A303 Sparkford to Ilchester Dualling Scheme TR010036

9.10 Table of Amendments to the Draft Development Consent Order Revision 0.1 to Revision 0.2 as Submitted At Deadline 2

Regulation Number:	Regulation 5(2)(q)
Planning Inspectorate Scheme Reference	TR010036
Application Document Reference	9.10
Author:	A303 Sparkford to Ilchester Dualling Scheme Project Team, Highways England

Version	Date	Status of Version
Rev A	January 2019	Deadline 2 submission

| Drawing Title FIGURE 2.4 RIGHTS OF WAY AND ACCESS PLANS - SHEET 3 OF 4 REGULATION 5(2)(k) and 5(2)(o) | | | | | |

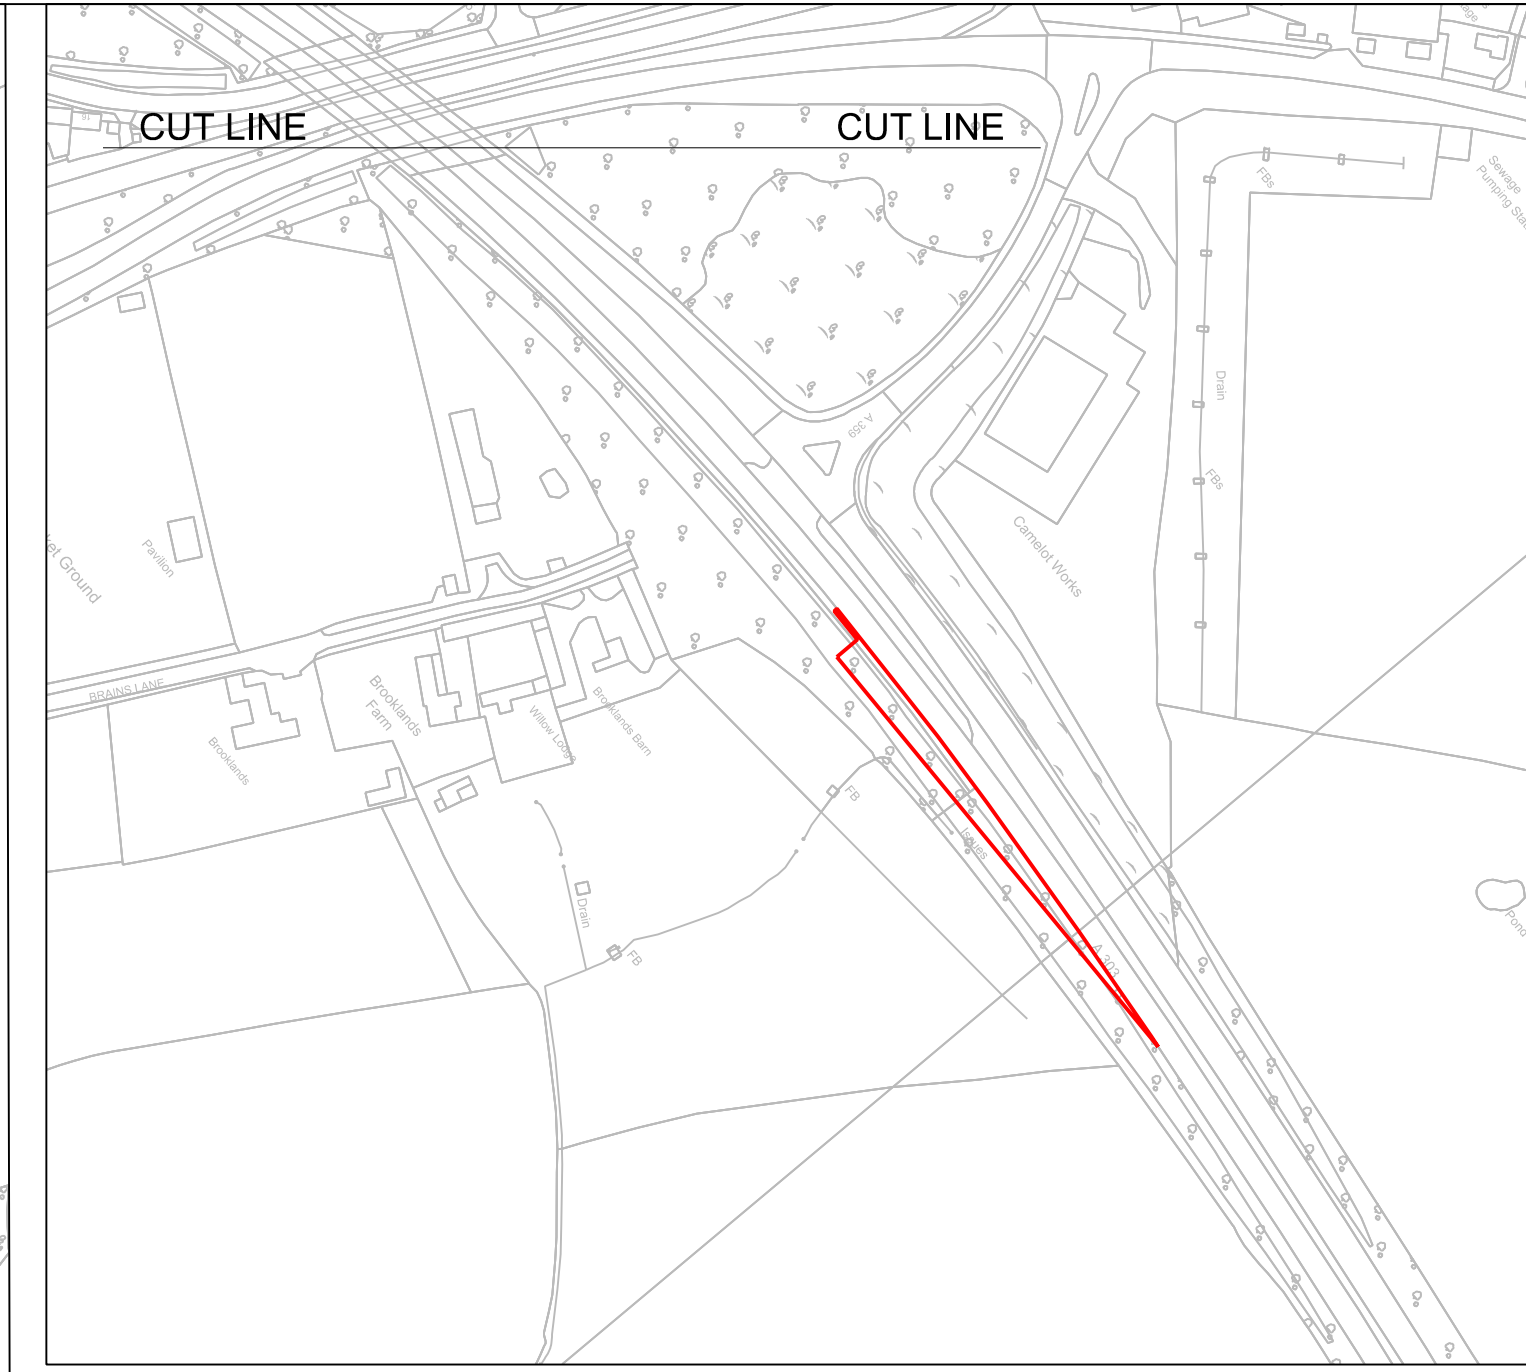
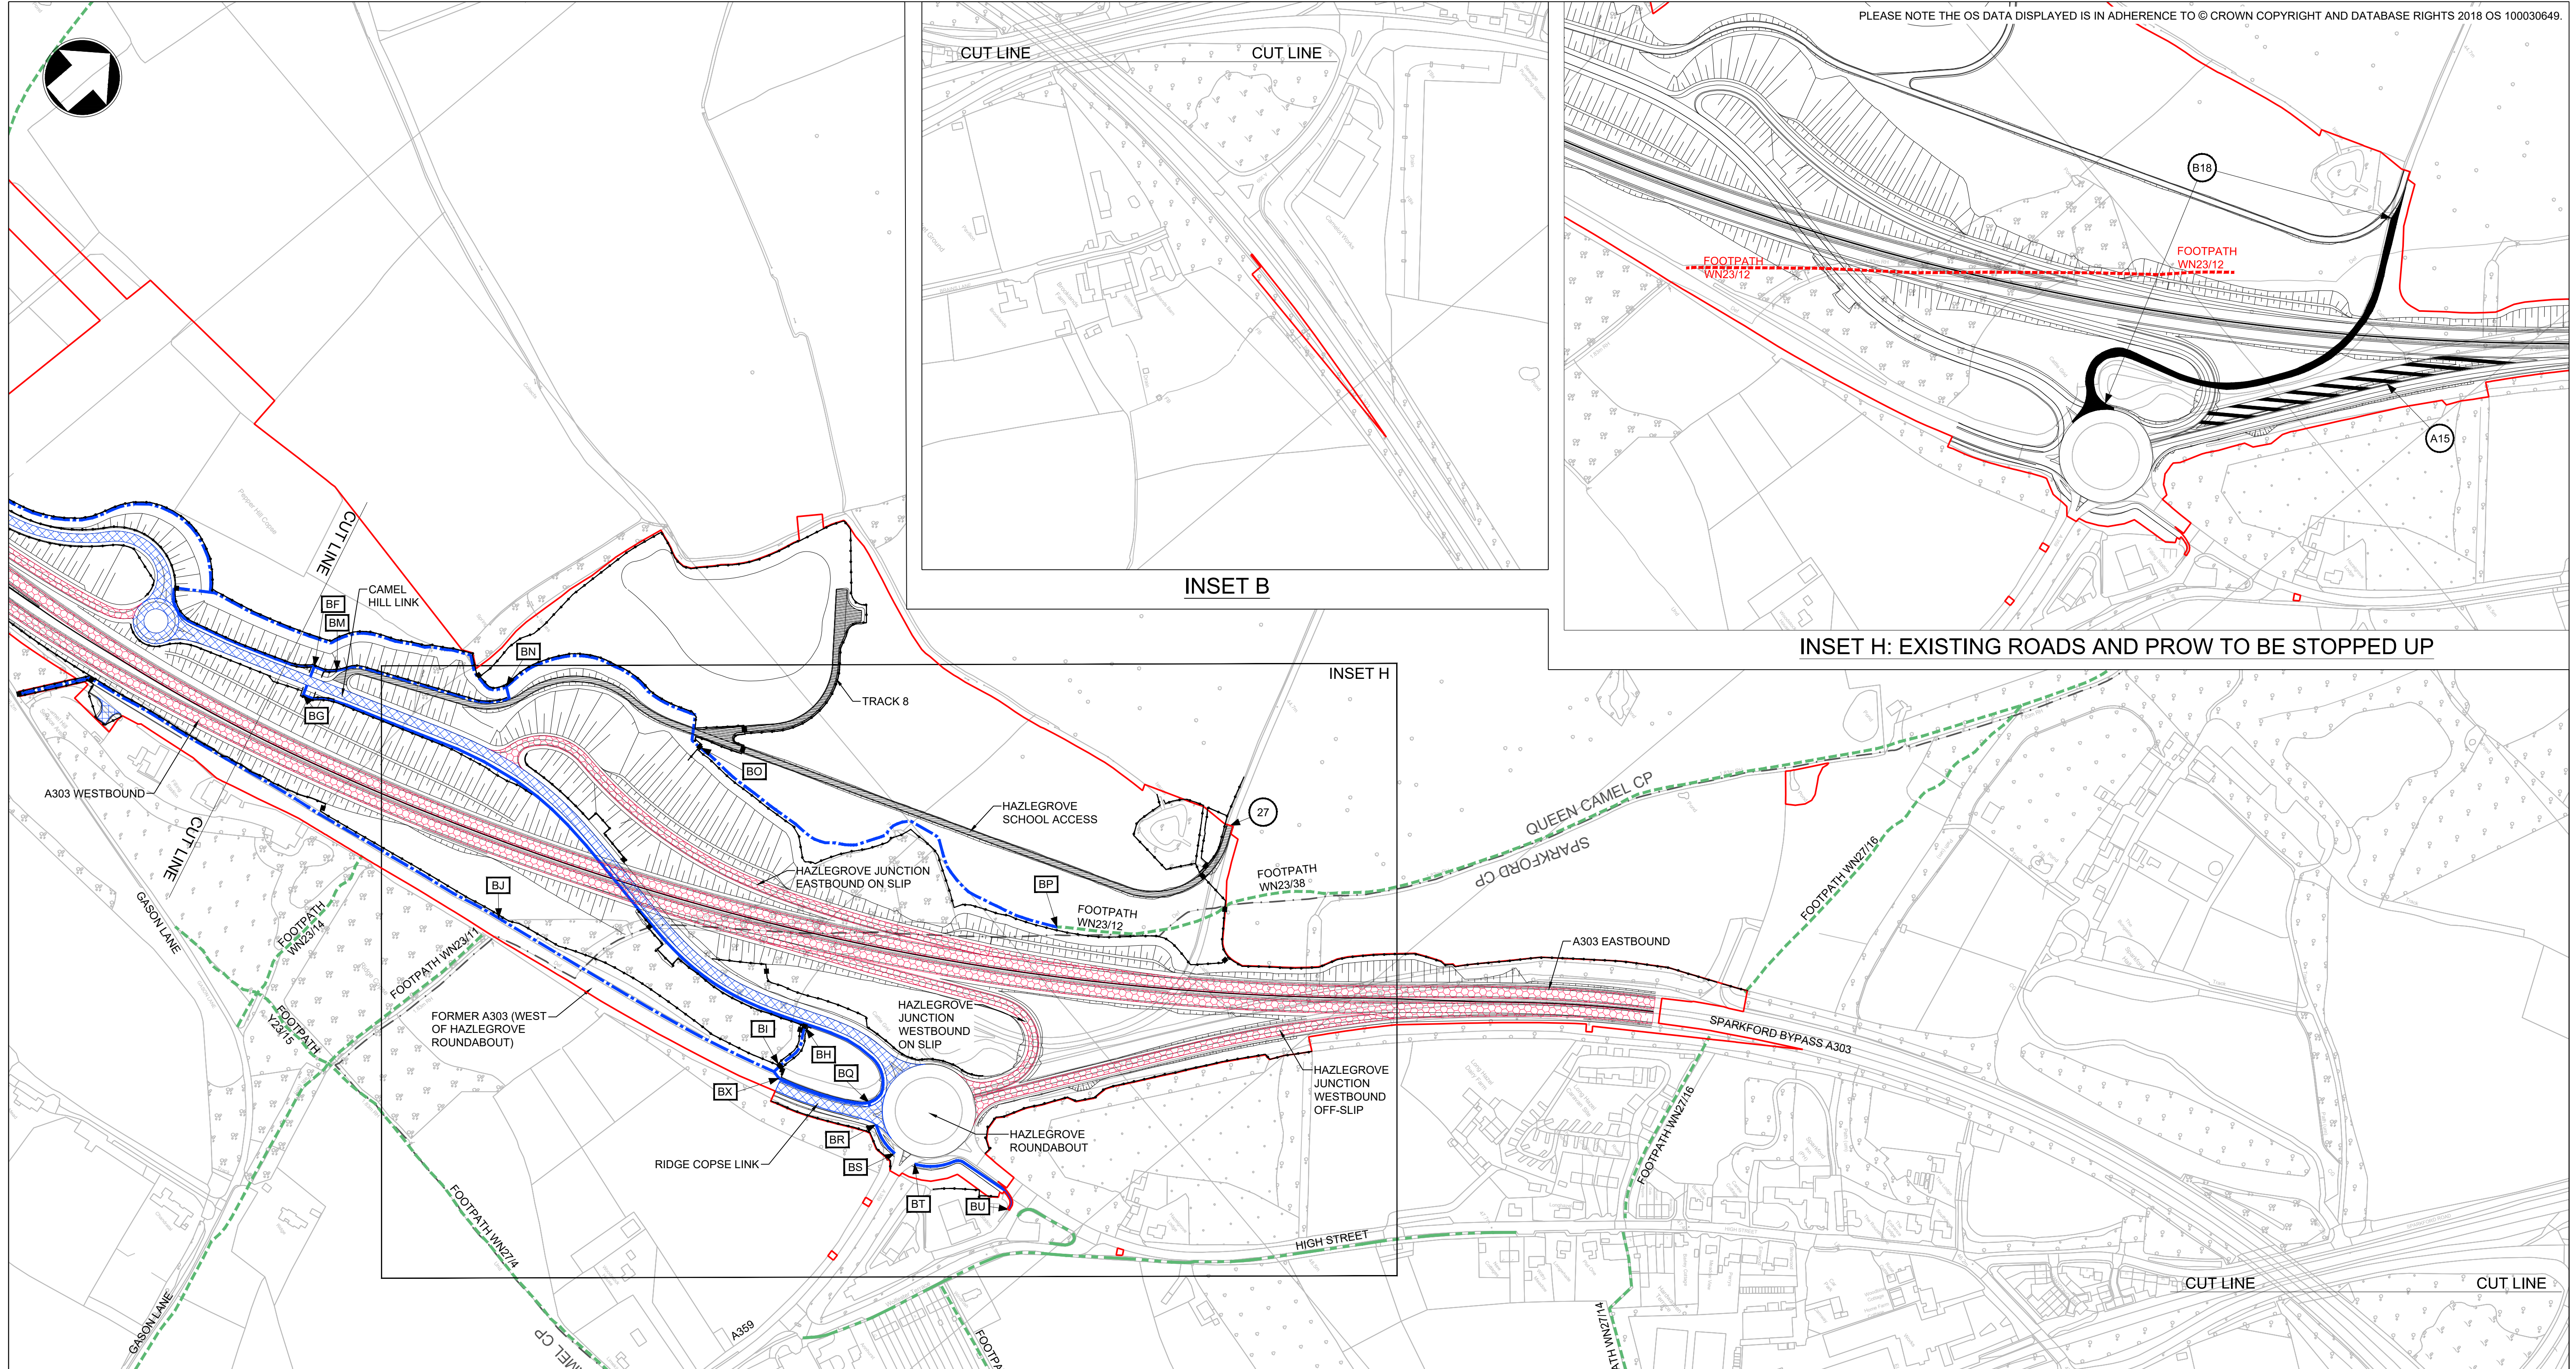
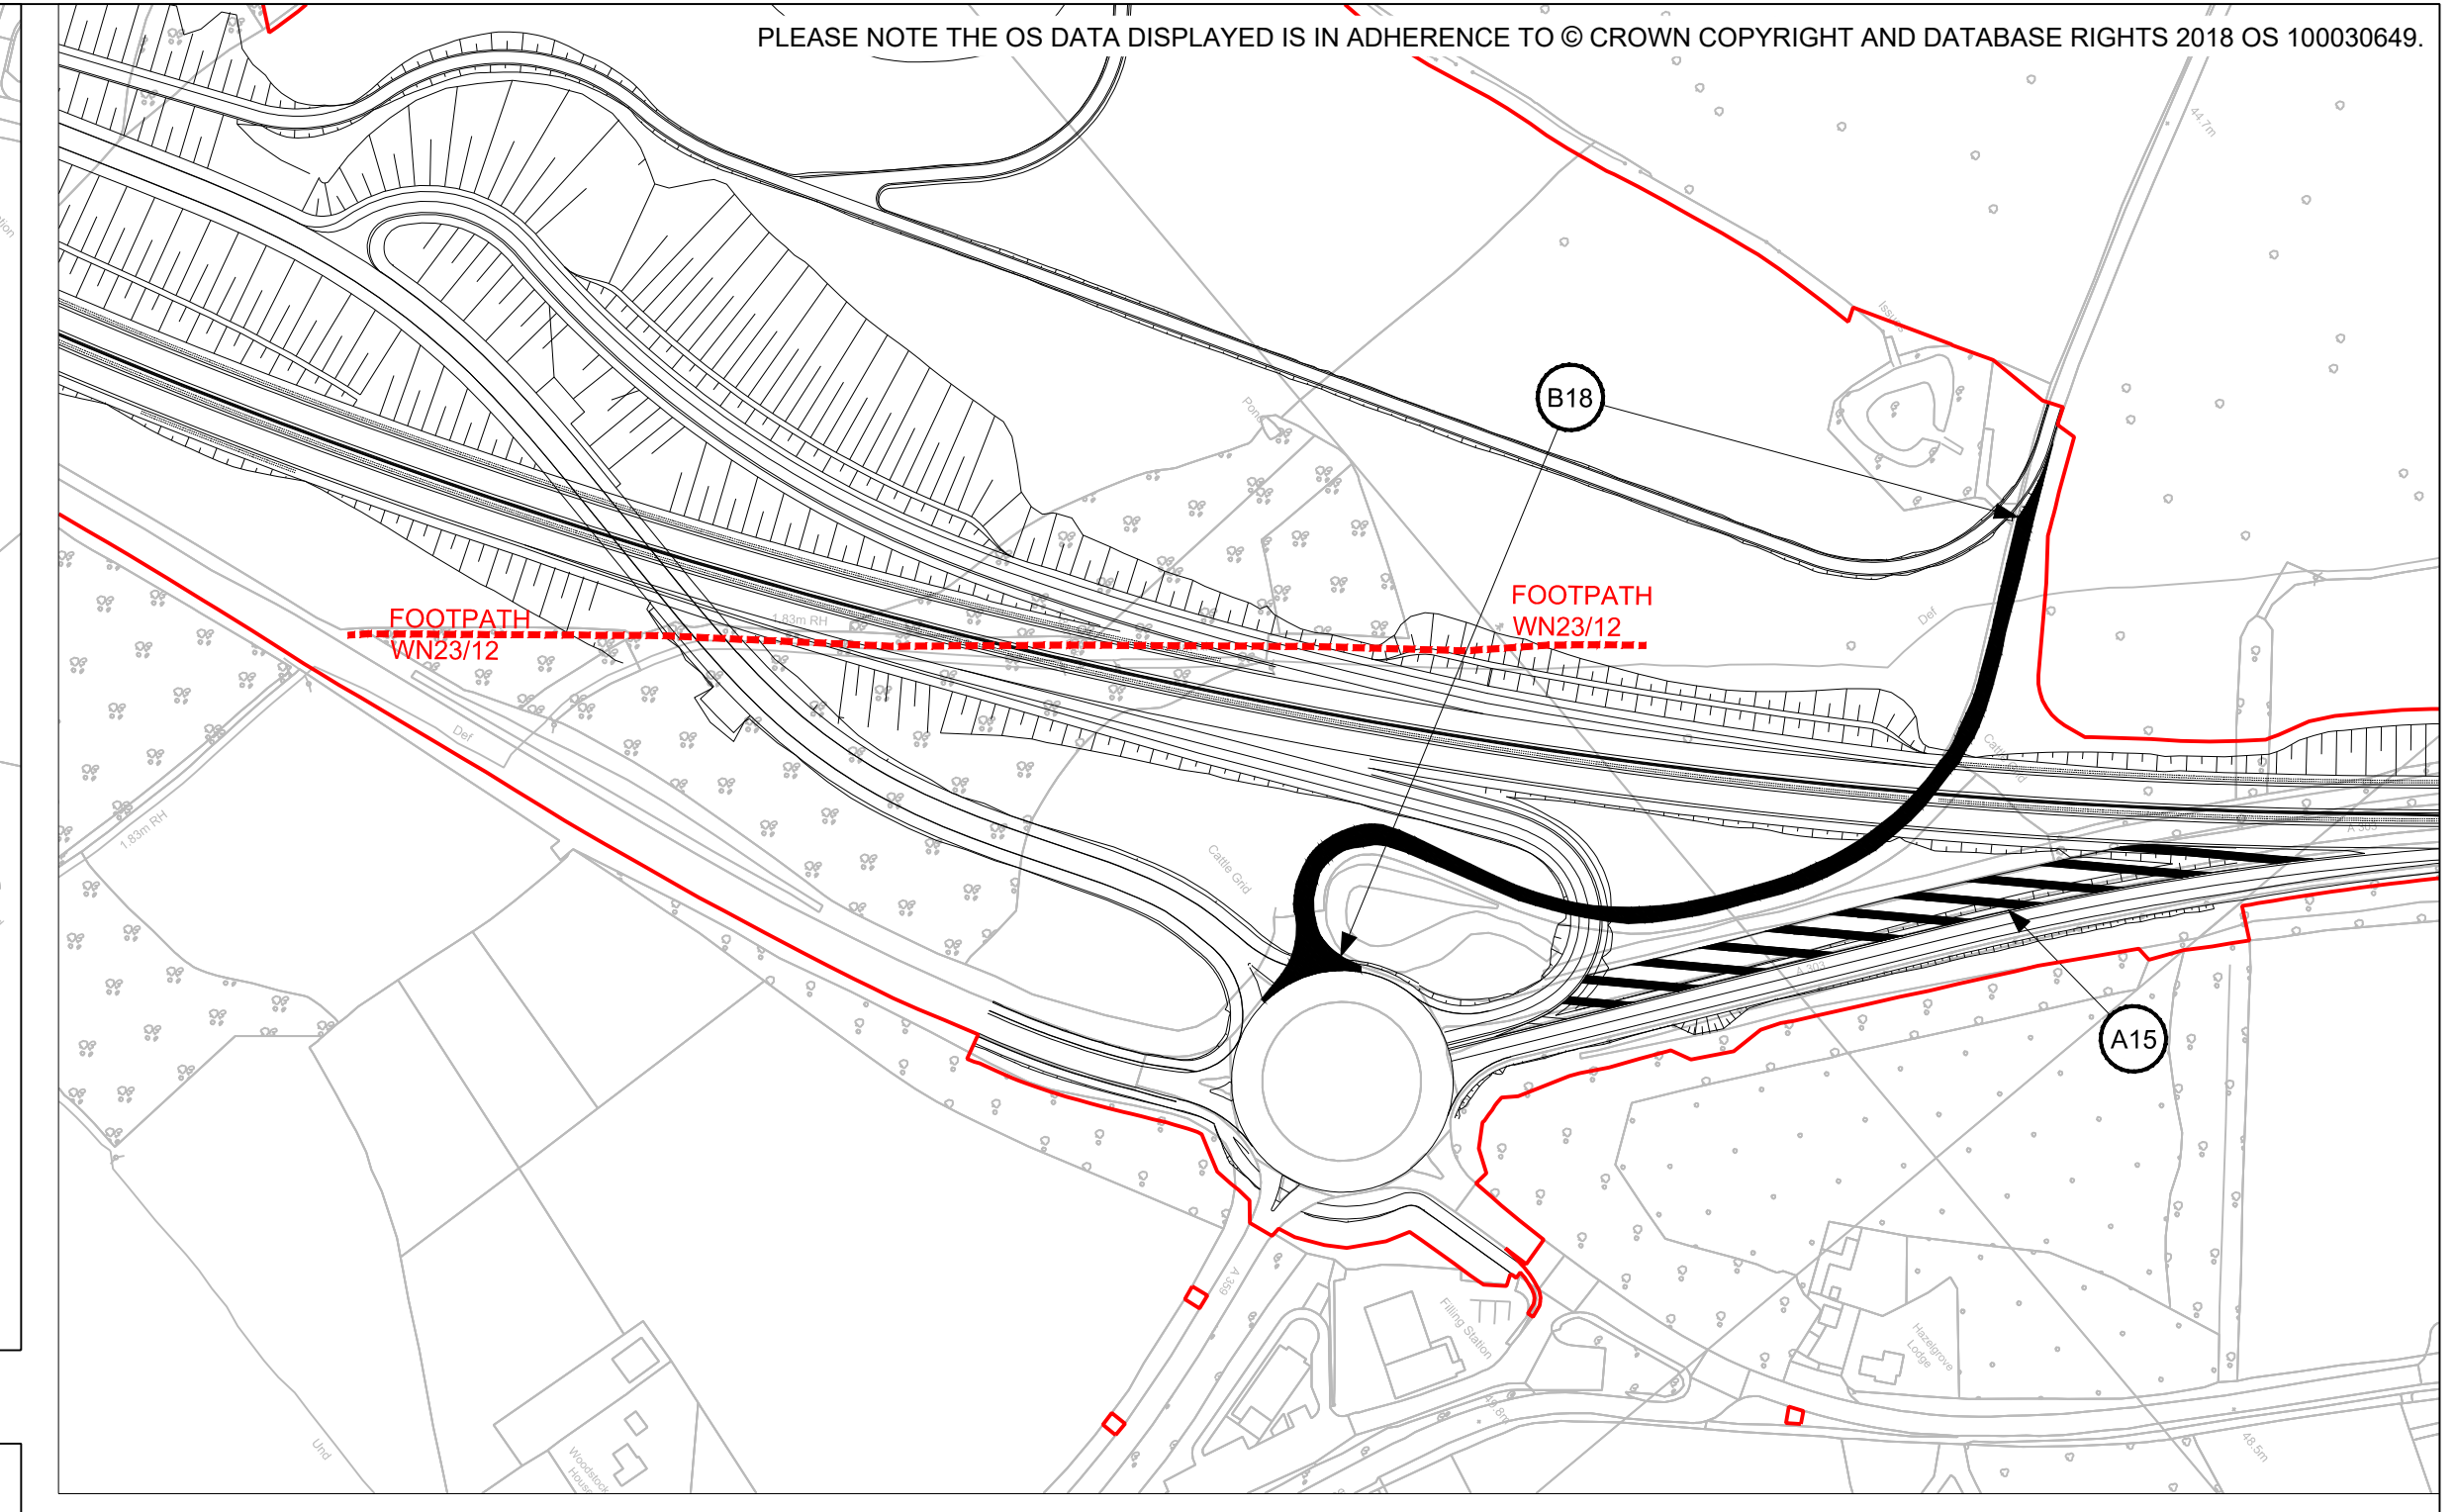
<p>and sub-written schemes of investigation referred to in sub-paragraph (1) unless otherwise agreed in writing by the Secretary of State.</p> <p>(3) A programme of archaeological reporting, post excavation and publication required as part of the archaeological framework strategy and sub-written schemes of investigation referred to in sub-paragraph (1) must be agreed with the County Archaeologist and implemented within a timescale agreed with the County Archaeologist and deposited with the Historic Environment Record of the relevant planning authority within two years of the date of completion of the authorised development or such other period as may be agreed in writing by the relevant planning authority.</p>						
1.7	1.10.41	Requirement 13(5)	Schedule 2 – Requirement 13(5) “... brought in by reference.” Can it be clarified to what reference is being made?	<p>Change made:</p> <p>Highway drainage will be designed in accordance with HD 33/16 Design of Highway Drainage Systems and any subsequent design manuals bought in by <u>reference amending or replacing that</u>.</p>						
1.8	1.10.45	Schedule 4 – Part 3, column (3)	Could this be clarified as this does not appear to make sense?	<p>Change made:</p> <table><tr><td>(1) Area</td><td>(2) Private means of access to be stopped up</td><td>(3) Extent of stopping up</td></tr><tr><td>Queen Camel</td><td>Reference 25. Access to land to the east of Camel Hill Farm, shown on sheet 3 of the Rights</td><td>Queen Camel <u>Reference 25 shown in solid black on sheet 3 of the Rights of Way and</u></td></tr></table>	(1) Area	(2) Private means of access to be stopped up	(3) Extent of stopping up	Queen Camel	Reference 25. Access to land to the east of Camel Hill Farm, shown on sheet 3 of the Rights	Queen Camel <u>Reference 25 shown in solid black on sheet 3 of the Rights of Way and</u>
(1) Area	(2) Private means of access to be stopped up	(3) Extent of stopping up								
Queen Camel	Reference 25. Access to land to the east of Camel Hill Farm, shown on sheet 3 of the Rights	Queen Camel <u>Reference 25 shown in solid black on sheet 3 of the Rights of Way and</u>

of Way and Access Plans	<u>Access Plans</u>	
--	--	--	--	--	------------------------------------	---------------------	--
